# CITY OF ALBUQUERQUE

**Re: Albuquerque Renal Construction, LLC Remodel  
Grading and Drainage Plan  
Engineer's Stamp Date 11-12-13 (K10D014)**

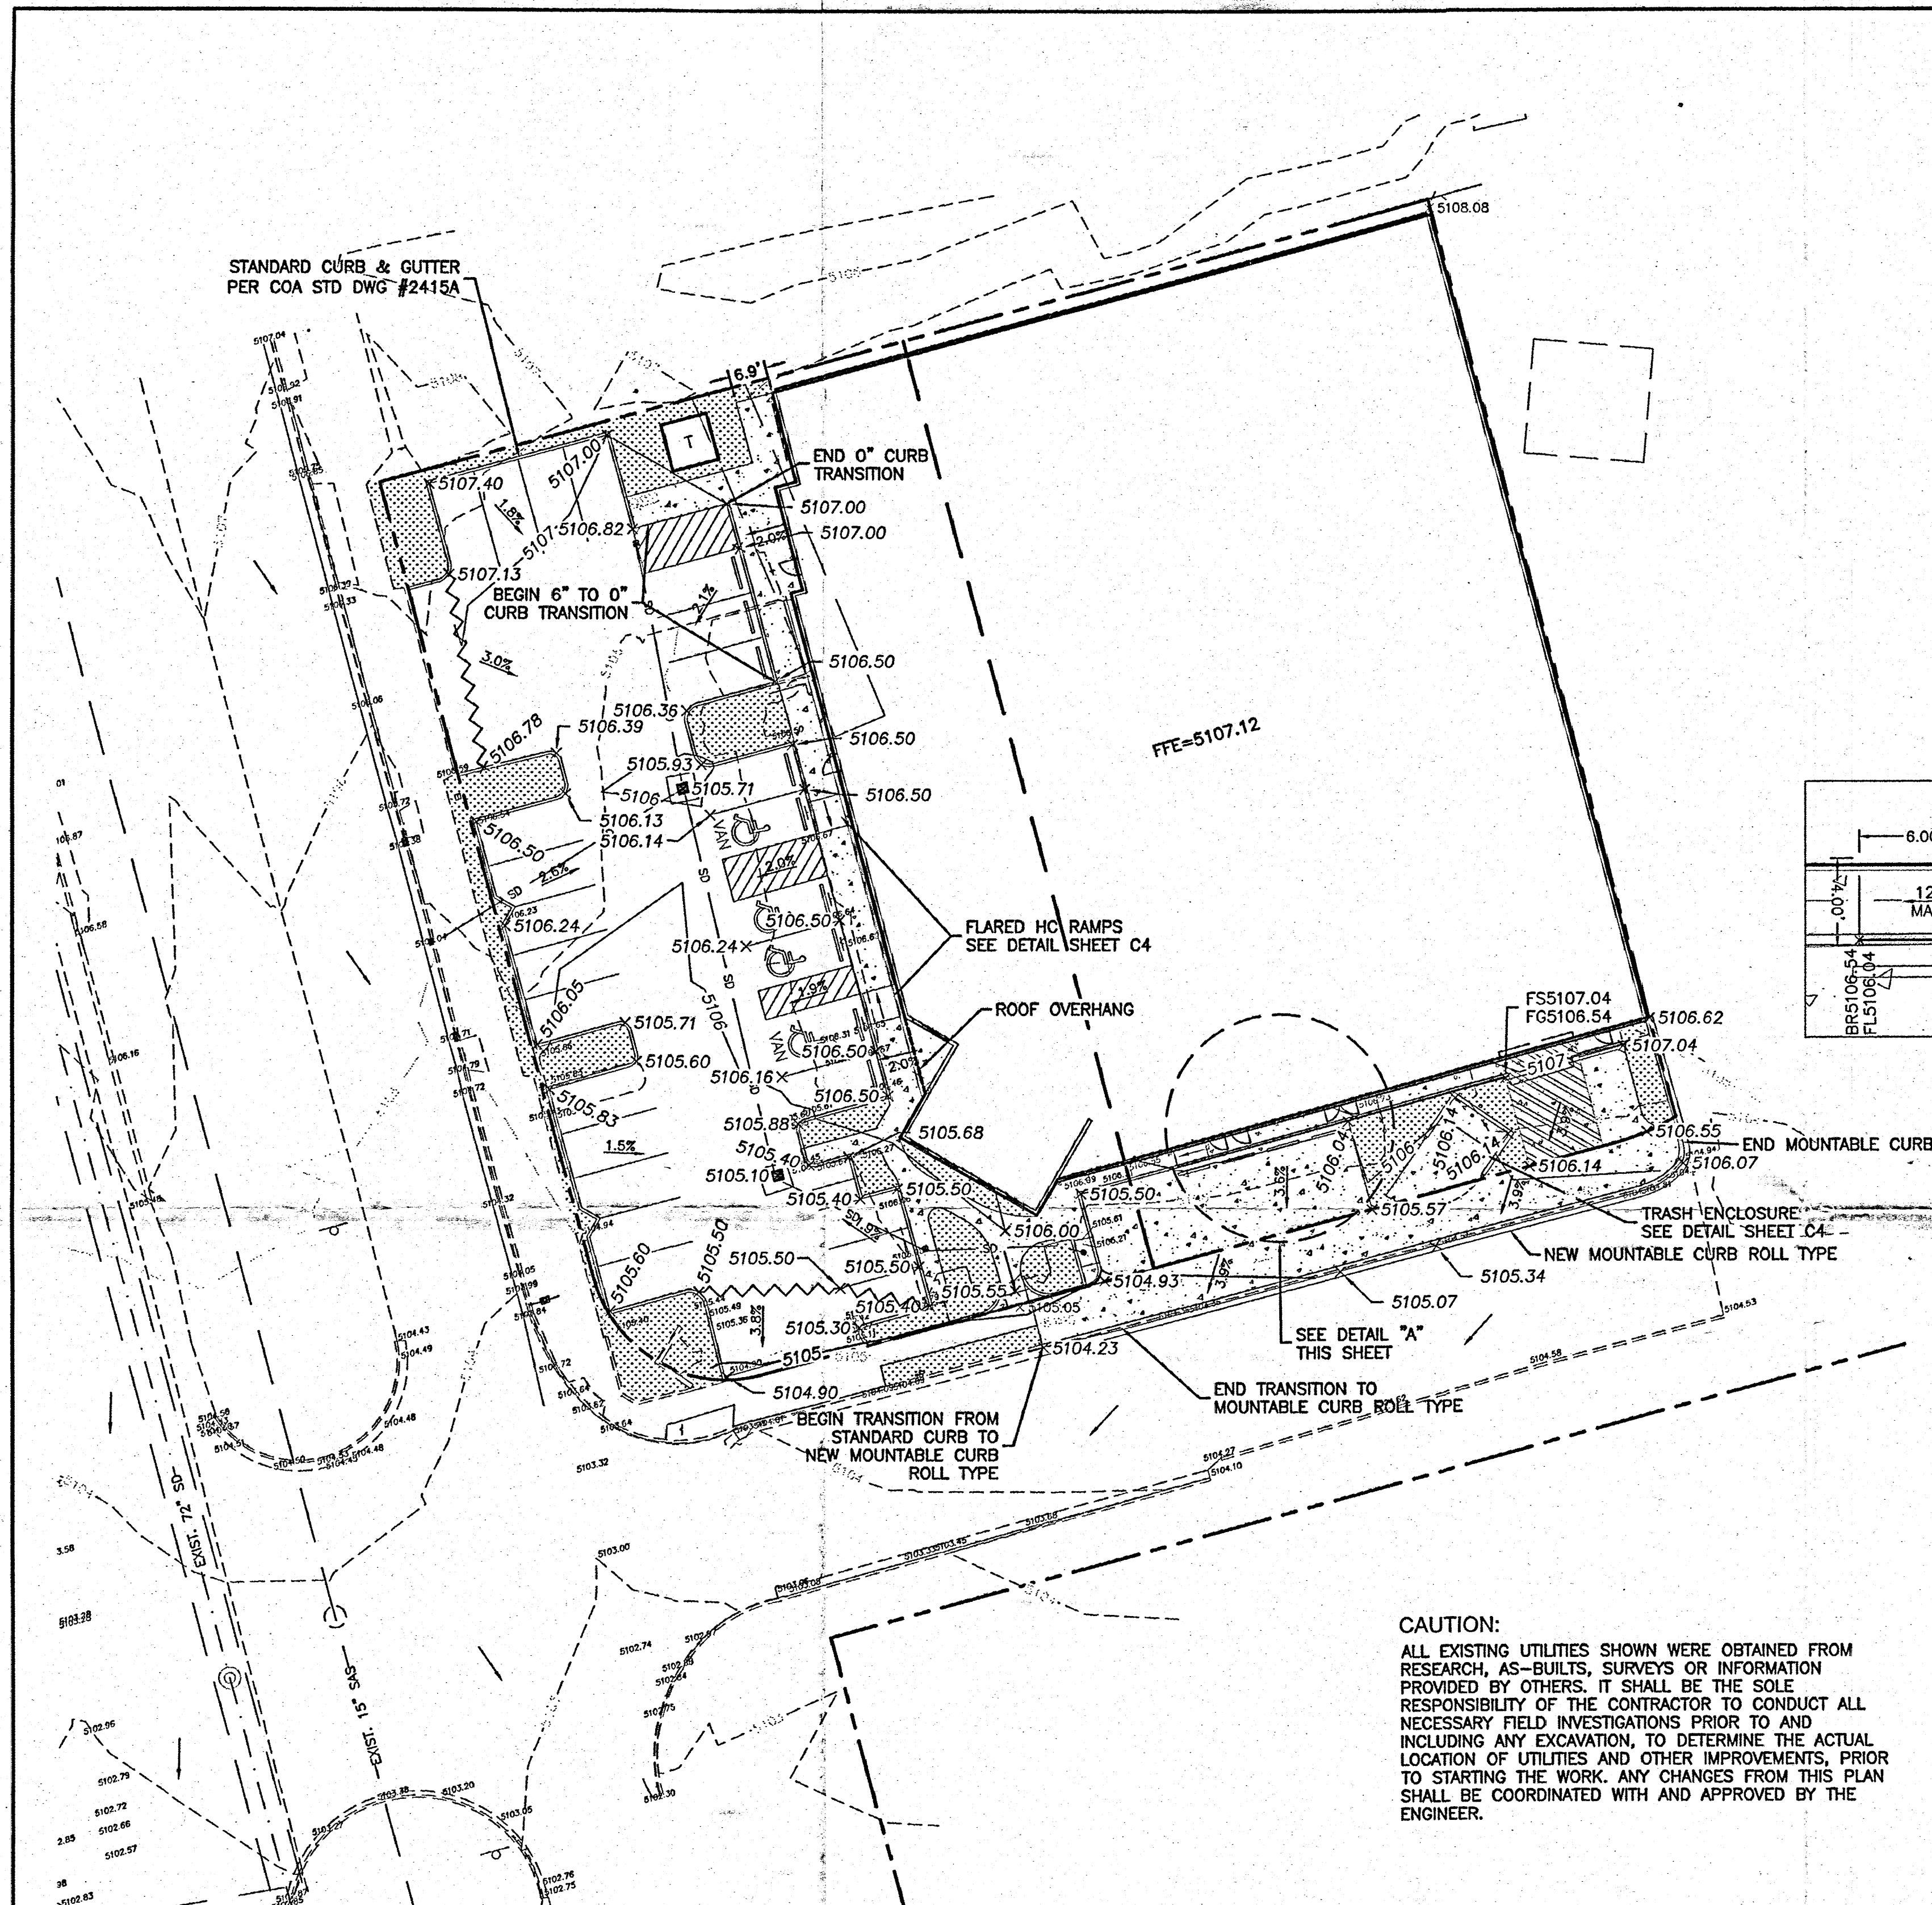
Based upon the information provided in your submittal received 12-09-13, the above referenced plan is approved for Building Permit and Paving Permit. Hydrology is asking that all landscaped areas are depressed to retain the moisture which falls on them.
